Mayfield West Recycling Facility SSD 7698 – Water Assessment

I refer to a letter to the Environment Protection Authority ("the EPA") dated 27 September 2017, prepared by EMM Consulting in relation to the Mayfield West Recycling Facility SSD 7698 and additional Water Assessment information.

Location of Surface Water Management Infrastructure

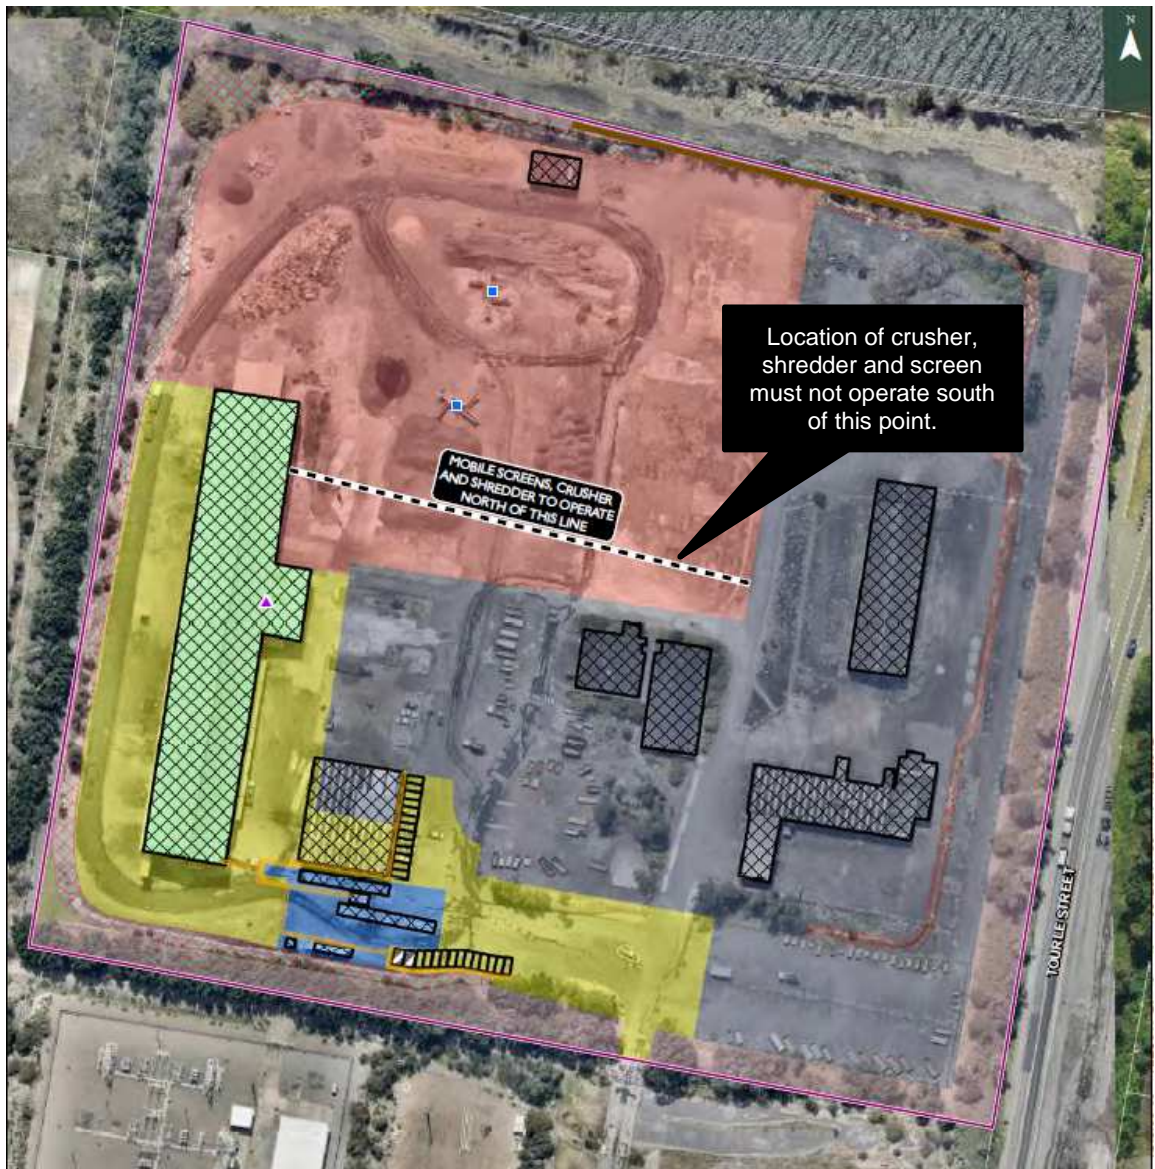
While storage tanks overflow to sewer, the key issue is overflow volume and frequency from the 3-stage pit system (for the potentially contaminated waste area) and also from other areas of the site subject to water quality testing, e.g. including the 24,990 m² area outside of the bunded segregated heavy waste processing and stockpiling area.

The pit system has a capacity of only 40,000 litres plus a pumping capacity of 20 litres per second and the pump activates when Cell 3 is about one third full. The overflow frequency from the 3-stage pit system is therefore dependent on the size of the pit system, plus the pumping rate and timing of activation. The frequency of potential overflow from this pit system is not defined or shown to be consistent with the Blue Book requirements. If post-consent water quality results indicate additional wet weather storage, at-source controls or further treatment is required, then any overflow from the pits may need to be at a reduced frequency commensurate with the risk. Similarly, if other areas of the site identify water quality risks the wet weather storage requirements and overflow frequency requirements may need to be greater than required by the Blue Book.

3. As part of the post-consent water quality assessment, the discharge quality and overflow volume and frequency from the 3-stage pit system and other areas of the site (outside the bunded area) be defined and where necessary, appropriate wet weather storage, at-source controls or further

treatment is implemented based on the risk identified in water quality assessment. It should be noted that even with further treatment using a water treatment plant that additional wastewater capture may be required to control the frequency of overflows relative to risk and treatment rate.
